Reference: **ACCESSIBILITY – ABERCROMBIE STREET
STUDENT ACCOMMODATION PROJECT**

ACCESS REPORT

ABERCROMBIE STUDENT ACCOMMODATION ABERCROMBIE STREET DARLINGTON NSW 2006

Revision C

1 GROUND FLOOR PLAN
SCALE 1:200 @ A1

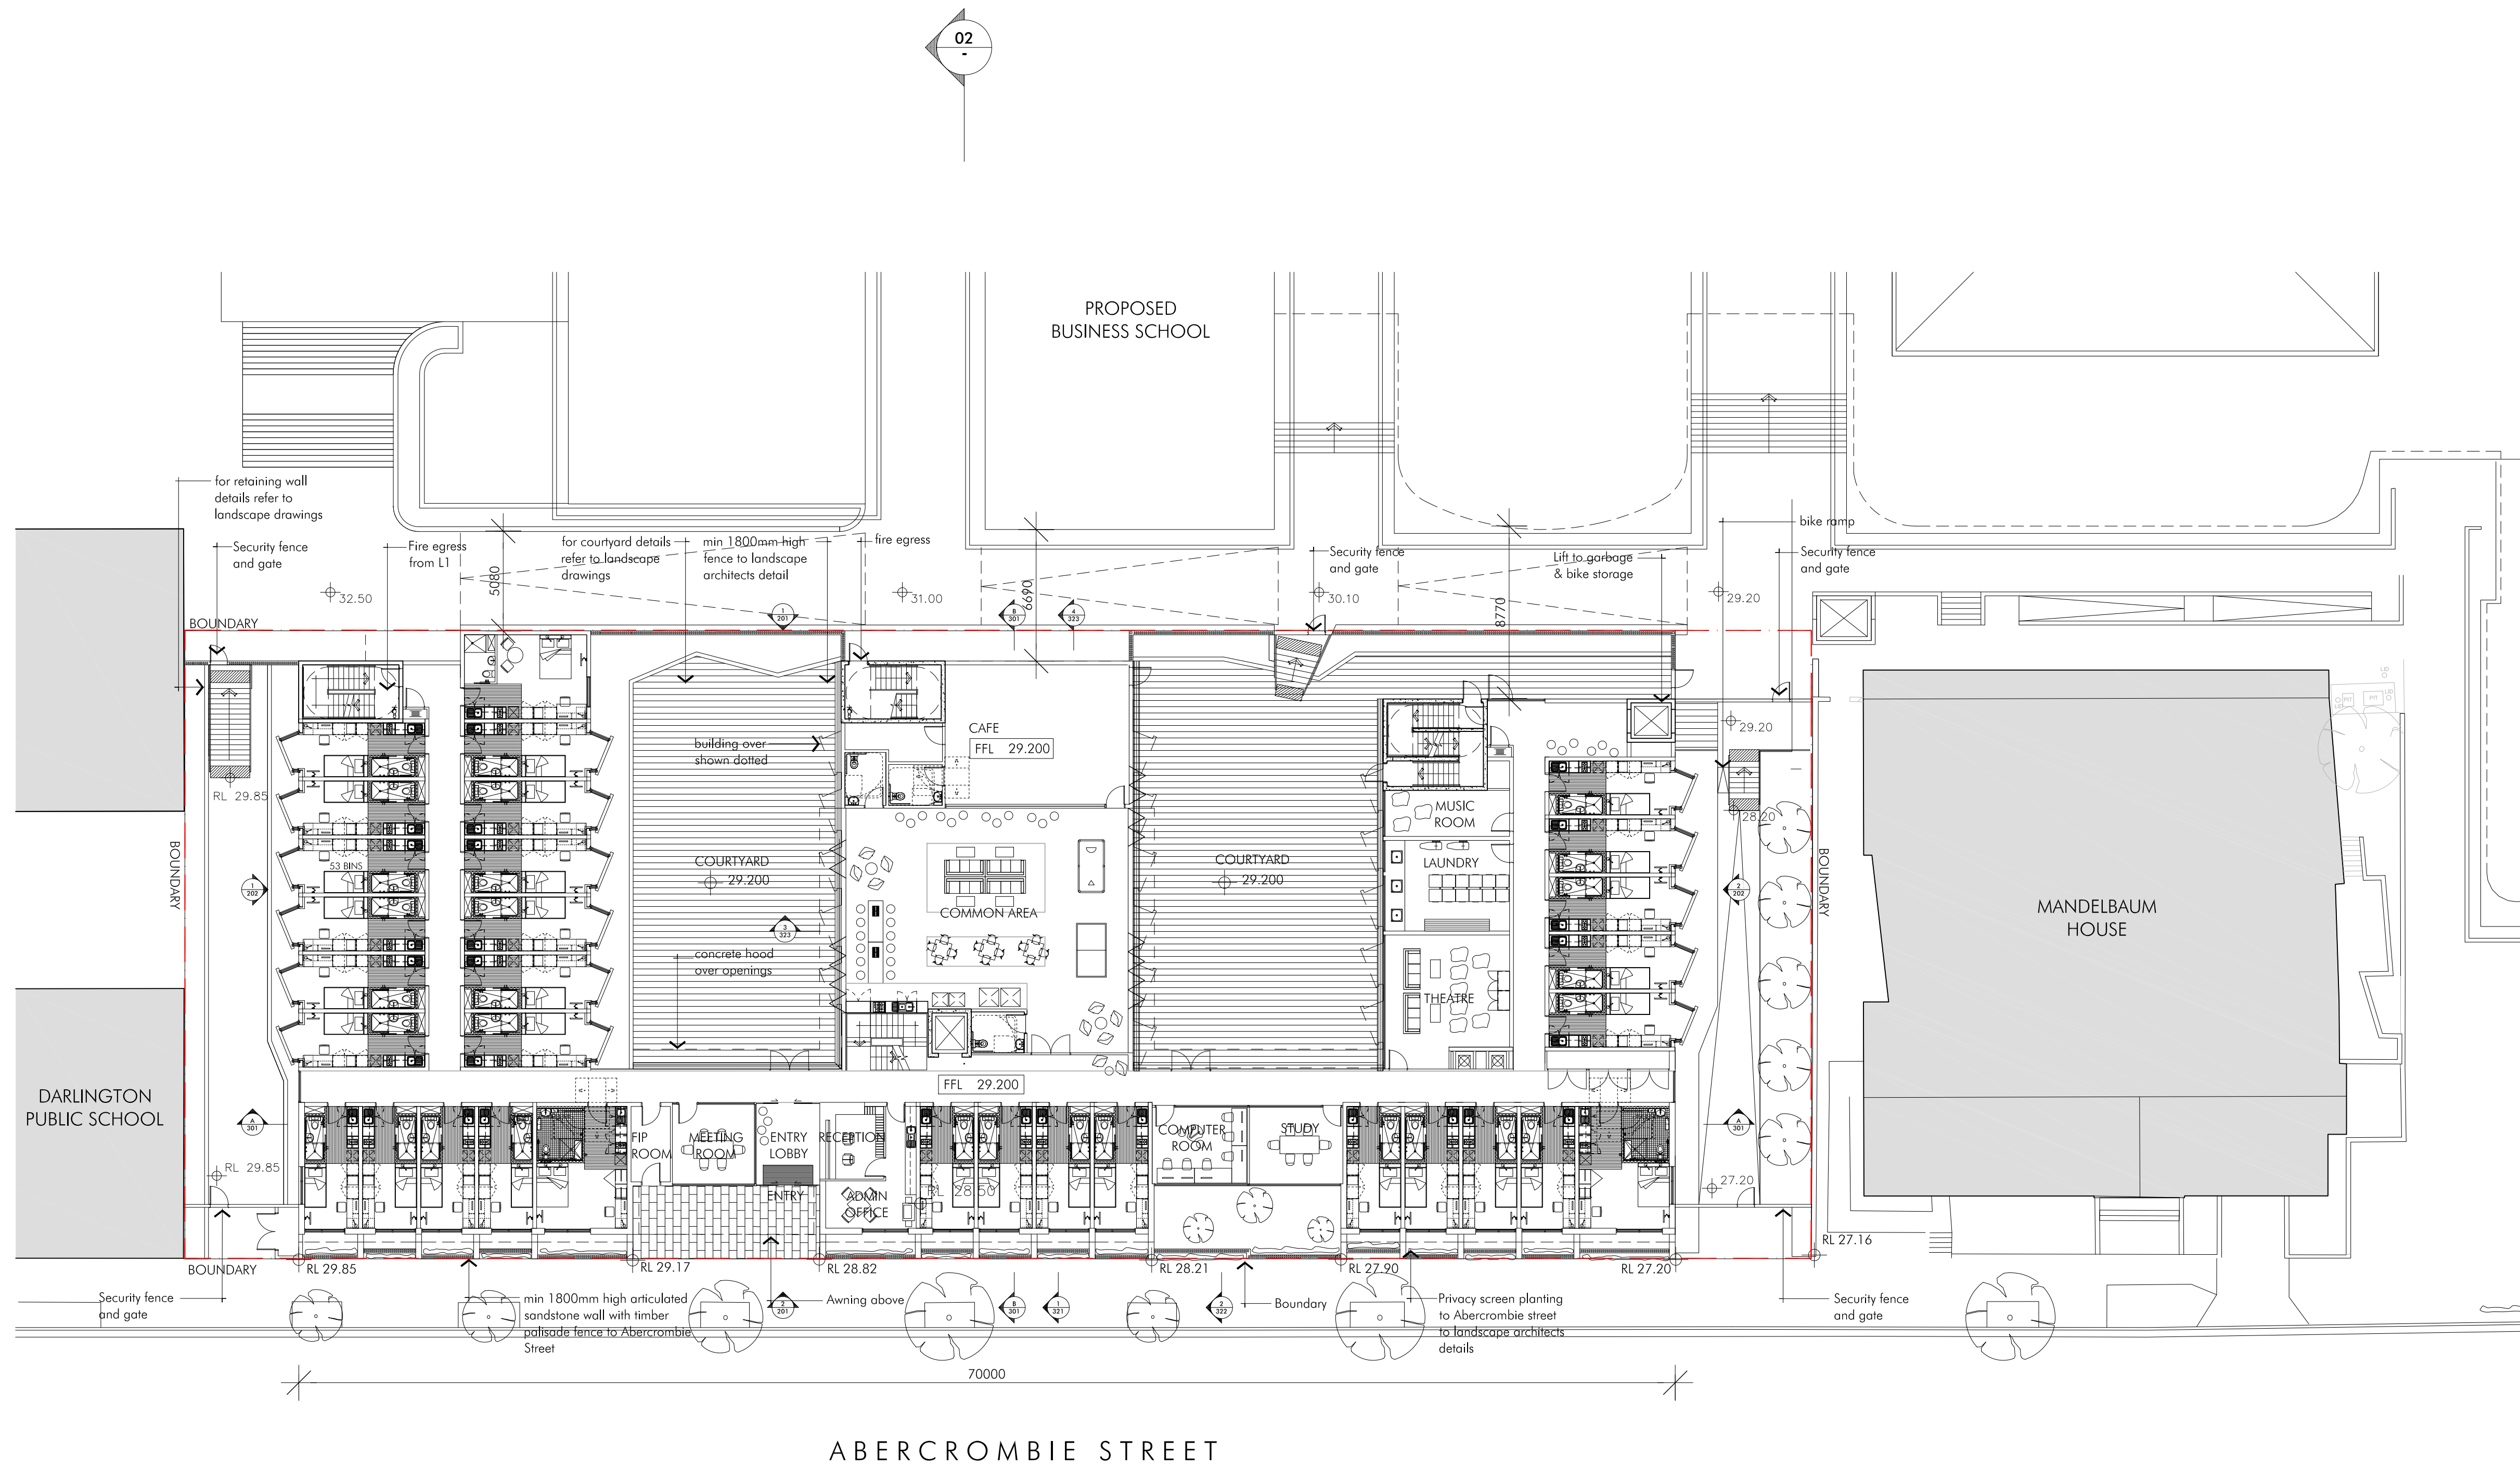
D3.1	General Building Access Requirements Class 3	
Table D3.1	Common areas - From a pedestrian entrance required to be accessible to at least one floor containing sole-occupancy units and to the entrance doorway of each sole-occupancy unit located on that level	Satisfied The detailed design for the entrance to the development at the front door on Abercrombie Street will need to demonstrate how the change in levels are addressed

2 ACCESSIBLE STUDIO-TYPE 2
SCALE 1:20 @ A1

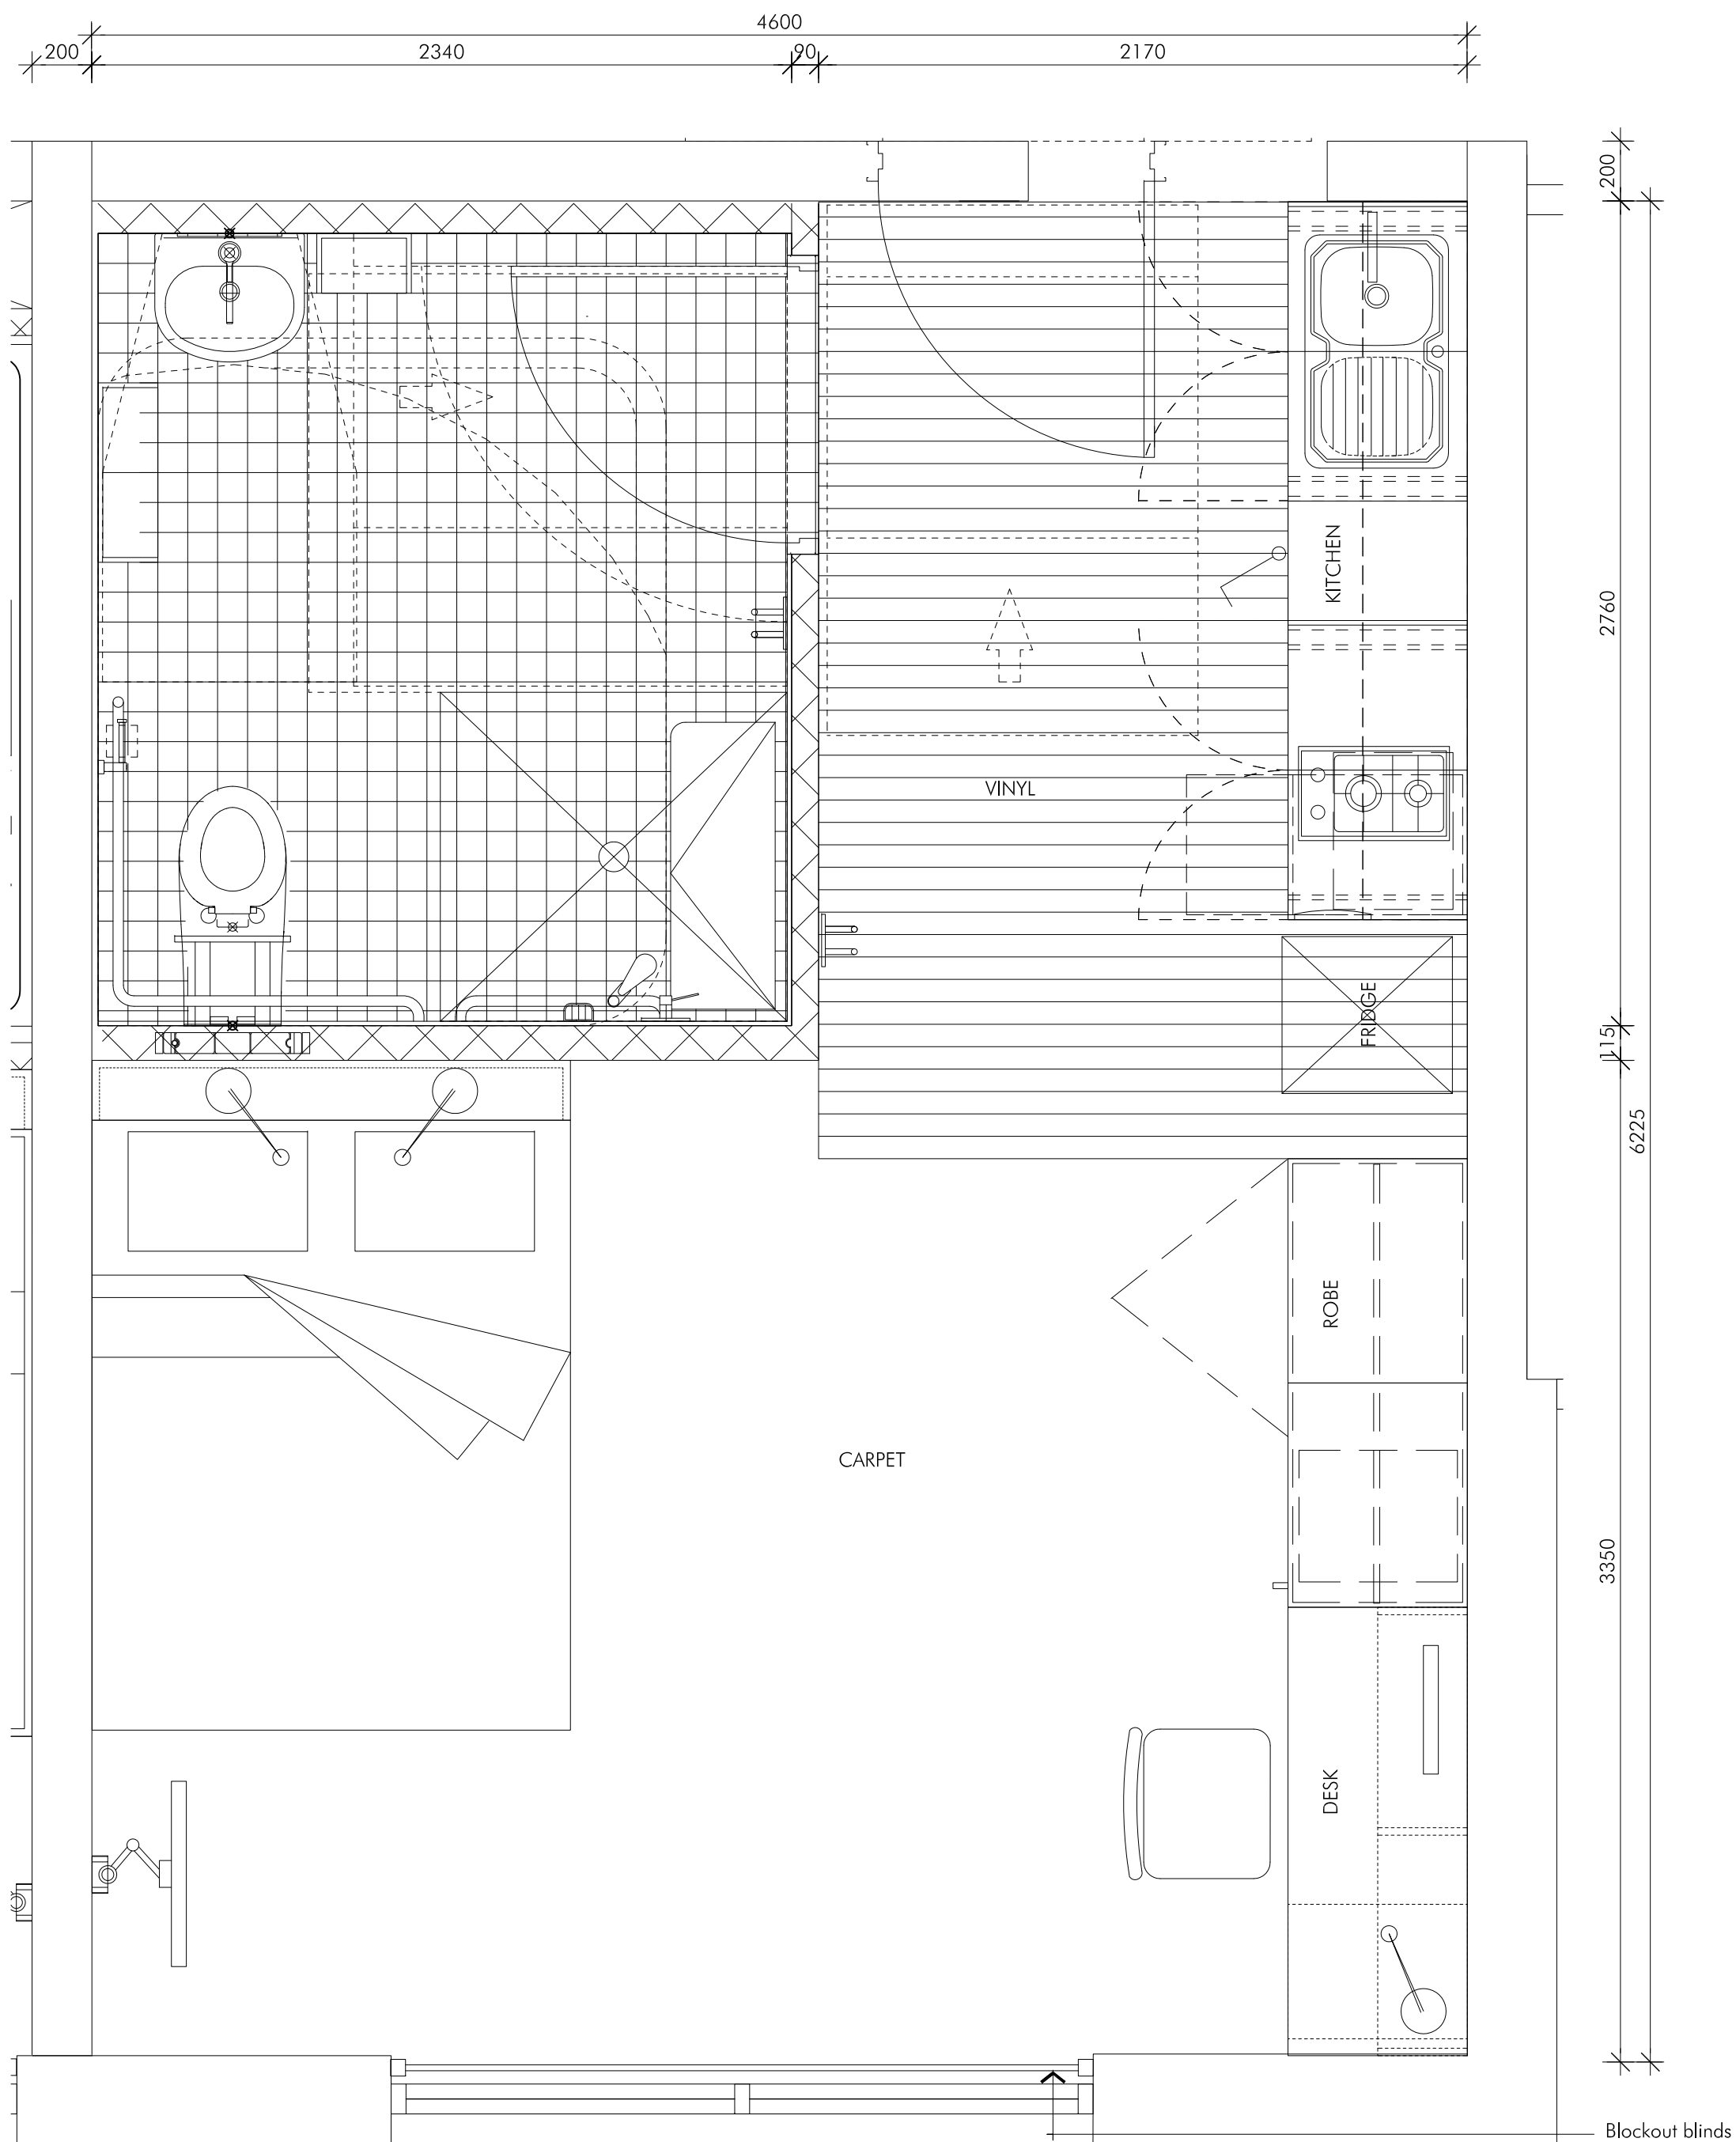
The development comprised 10 accessible rooms located across the building. The designs of these rooms indicate an accessible toilet/shower arrangements and circulation areas. The detailing of the joinery elements to be installed in the rooms will need to be reviewed when detailed.
